From: Thomas Callaway
Sent: 04 June 2015 10:46
To: Planning.Responses
Subject: RE: Planning Consultation on: M/49/15/HH

APPLICATION M/49/15/HH

Site Address: 24 Southdean Drive Middleton-on-Sea PO22 7SX

Description of Works: Conversion of existing integral garage into habitable space to include single storey extension.

PROPOSED ROOF PLAN

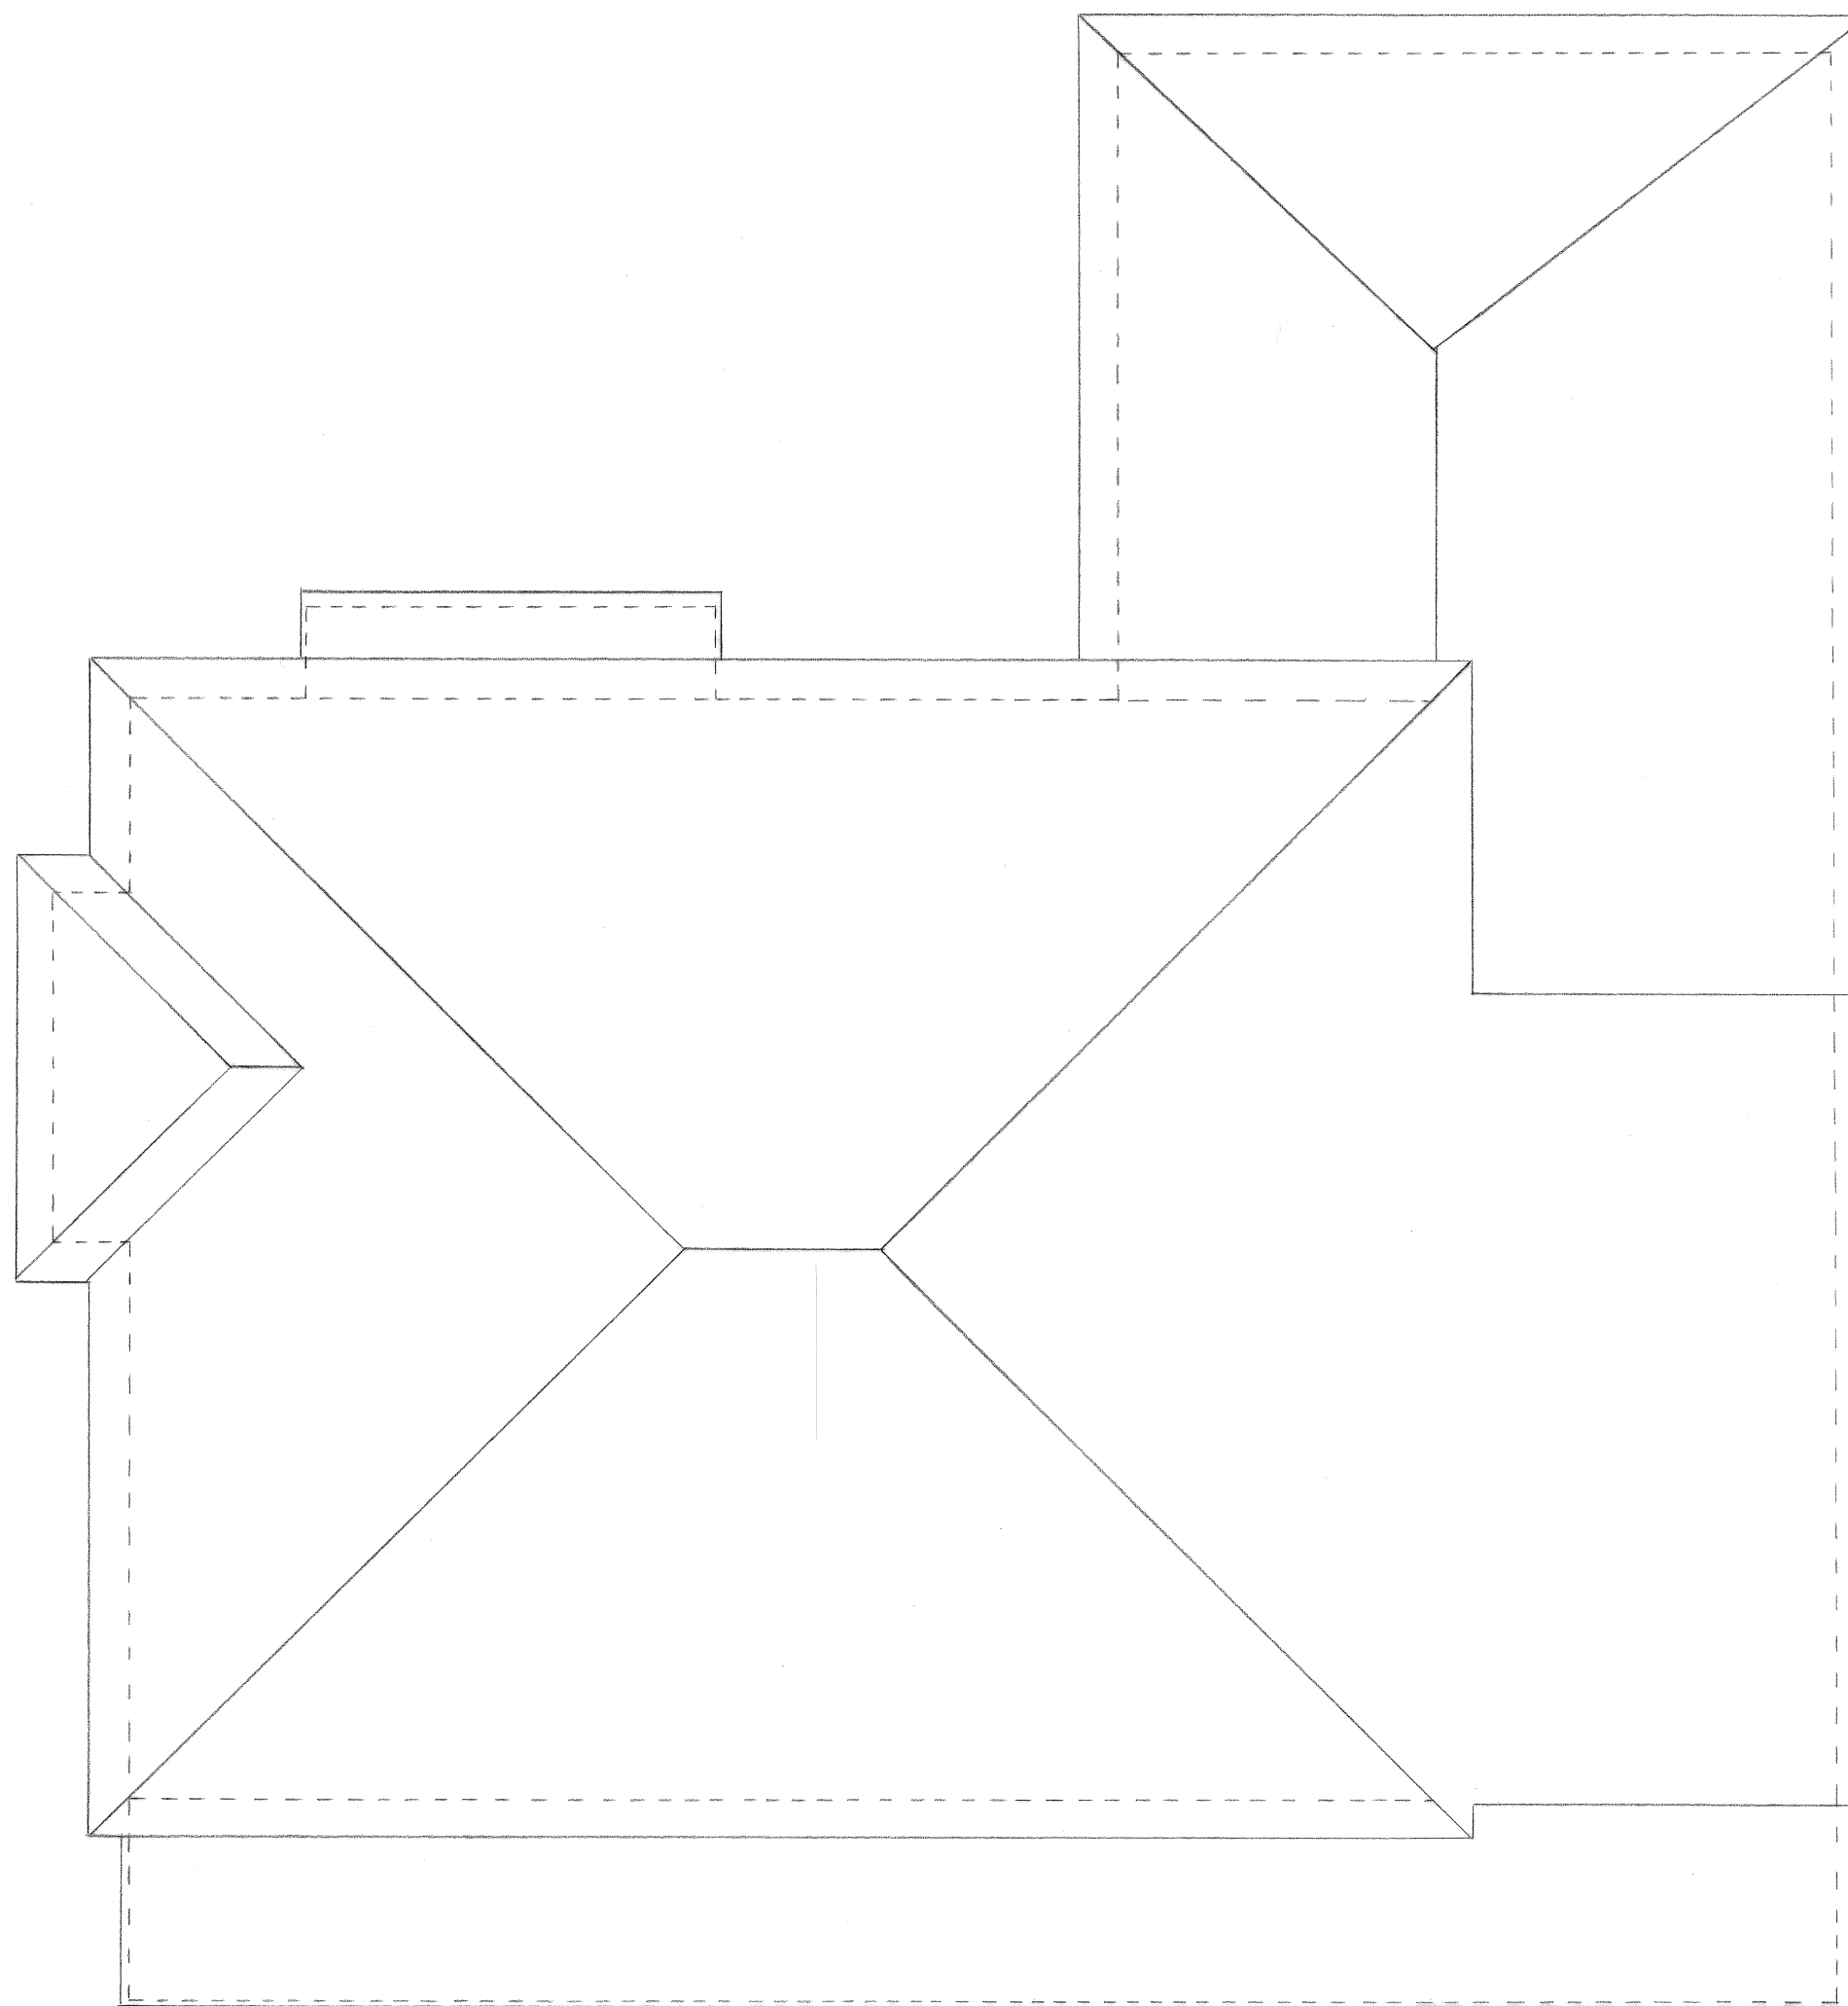
Soakage should be investigated for new roof area.

Please apply standard conditions ENGD2A.

Infiltration rates for soakage structures are to be based on percolation tests undertaken in the winter period and at the location and depth of the proposed structures. The percolation tests must be carried out in accordance with BRE 365, CIRIA R156 or a similar approved method and cater for the 1 in 10 year storm between the invert of the entry pipe to the soakaway, and the base of the structure. It must also have provision to ensure that there is capacity in the system to contain below ground level the 1 in 100 year event plus 30% on stored volumes, as an allowance for climate change. Adequate freeboard must be provided between the base of the soakaway structure and the highest recorded annual groundwater level identified in that location.

Any SuDS or soakaway design must include adequate groundwater monitoring data to determine the highest winter groundwater table in support of the design. The applicant is advised to discuss the extent of groundwater monitoring with the Council's Engineers. Supplementary guidance notes are also enclosed for information.
